**WELWYN HATFIELD BOROUGH COUNCIL
EXECUTIVE DIRECTOR - PLANNING, PUBLIC PROTECTION AND GOVERNANCE**

Application No: 6/2020/2046/LAWP
Location: Meadow View Wyndham Cottage Camfield Place Kentish Lane
 Hatfield AL9 6JE
Proposal: Certificate of lawfulness for proposed side dormers
Officer: Mr Tom Gabriel

Recommendation: Refused

4.	Plan Number	Revision Number	Details	Received Date
	222		Proposed Plans and Elevations	13 August 2020
	14111-S-001-1st		Survey Drawings	13 August 2020

Roof Plan 1:100

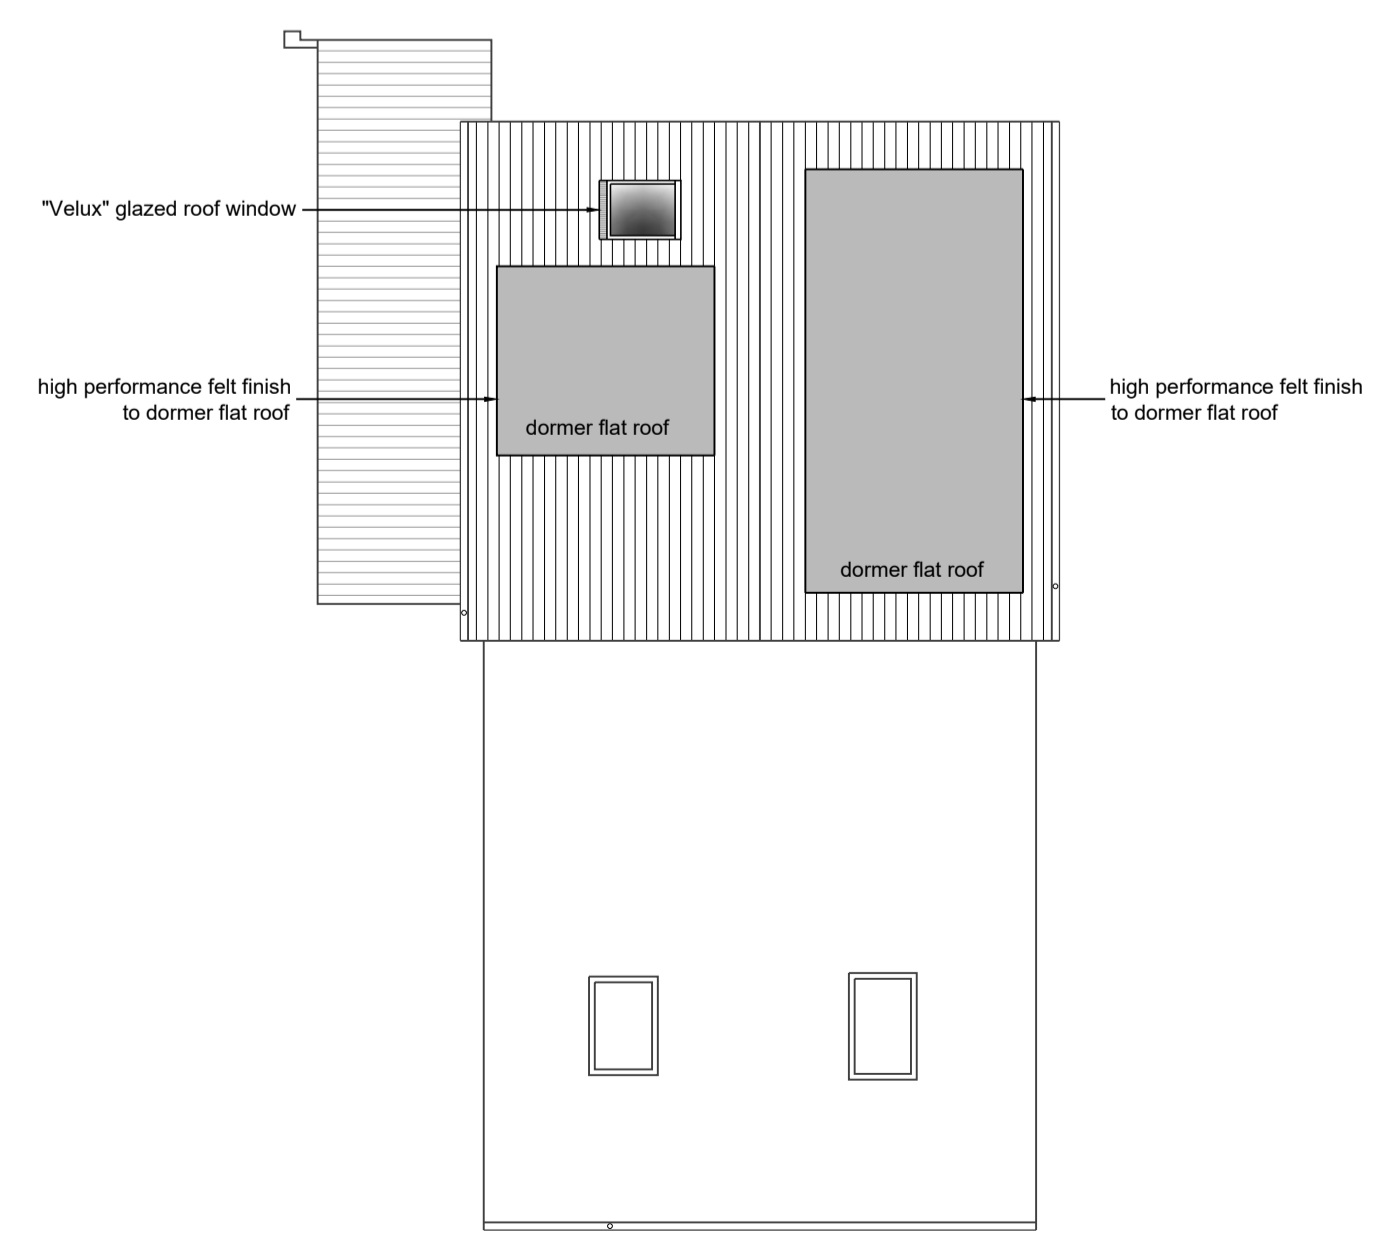
(d) would the cubic content of the resulting roof space exceed the cubic content of the original roof space by more than:- (i) 40 cubic metres in the case of a terrace house, or (ii) 50 cubic metres in any other case	N see below	N
<p><u>Calculation</u></p> <p>Big dormer: $(1/2 \times (5.75 (w) \times 2.2 (h) \times 2.4 (d)) = 14.7 \text{ m}^3$</p> <p>Little dormer $(1/2 \times (2.7 (w) \times 2.2 (h) \times 2.4 (d)) = 7.13 \text{ m}^3$</p> <p>Total = 21.83 m³</p>

<p>B.2 Development is permitted by Class B subject to the following conditions:-</p> <p>(a) the materials used in any exterior work shall be of a similar appearance to those used in the construction of the exterior of the existing dwellinghouse</p> <p>(b) is the enlargement constructed so that-</p> <p>(i) other than in the case of a hip-to-gable enlargement or an enlargement which joins the original roof to the roof of a rear or side extension –</p> <p>(aa) the eaves of the original roof are maintained or reinstated: and</p> <p>(bb) the edge of the enlargement closest to the eaves of the original roof shall, so far as practicable, be not less than 20 centimetres from the eaves, measured along the roof slope from the outside edge of the eaves; and</p> <p>(ii) other than in the case of an enlargement which joins the original roof to the roof of a rear or side extension, no part of the enlargement extends beyond the outside face of any external wall of the original dwellinghouse.</p> <p>(c) any window inserted on a wall or roof slope forming a side elevation of the dwellinghouse shall be –</p> <p>(i) obscure-glazed, and</p> <p>(ii) non-opening unless the parts of the window which can be opened are more than 1.7 metres above the floor of the room in which the window is installed</p>	<p>N – not specified on the plans or in the application form</p> <p>Y</p> <p>Y</p>

C.2 Development is permitted by Class C subject to the condition that any window located on a roof slope forming a side elevation of the dwellinghouse must be— (a) obscure-glazed; and (b) non-opening unless the parts of the window which can be opened are more than 1.7 metres above the floor of the room in which the window is installed.	Not specified	Y
---	---------------	---

Conclusion
The proposed development incorporating two side dormer windows and one side velux window may not be classed as permitted development and therefore requires planning permission.

1. The proposal fails to be classed as permitted development as the permitted development rights for the dwelling were removed when permission was granted for it.
2. The proposal has been assessed against and fails to comply with the conditions and limitations of Schedule 2, Part 1, Class B of The Town and Country (General Permitted Development) Order 2015 (as amended) as the materials for the development have not been specified.
3. The proposal has been assessed against and it is not known whether it complies with the conditions and limitations of Schedule 2, Part 1, Class C of The Town and Country (General Permitted Development) Order 2015 (as amended) as it has not been specified how far the velux window would project from the roofslope and whether that part of the velux window 1.7m above internal floor level would be obscure glazed and non-opening.
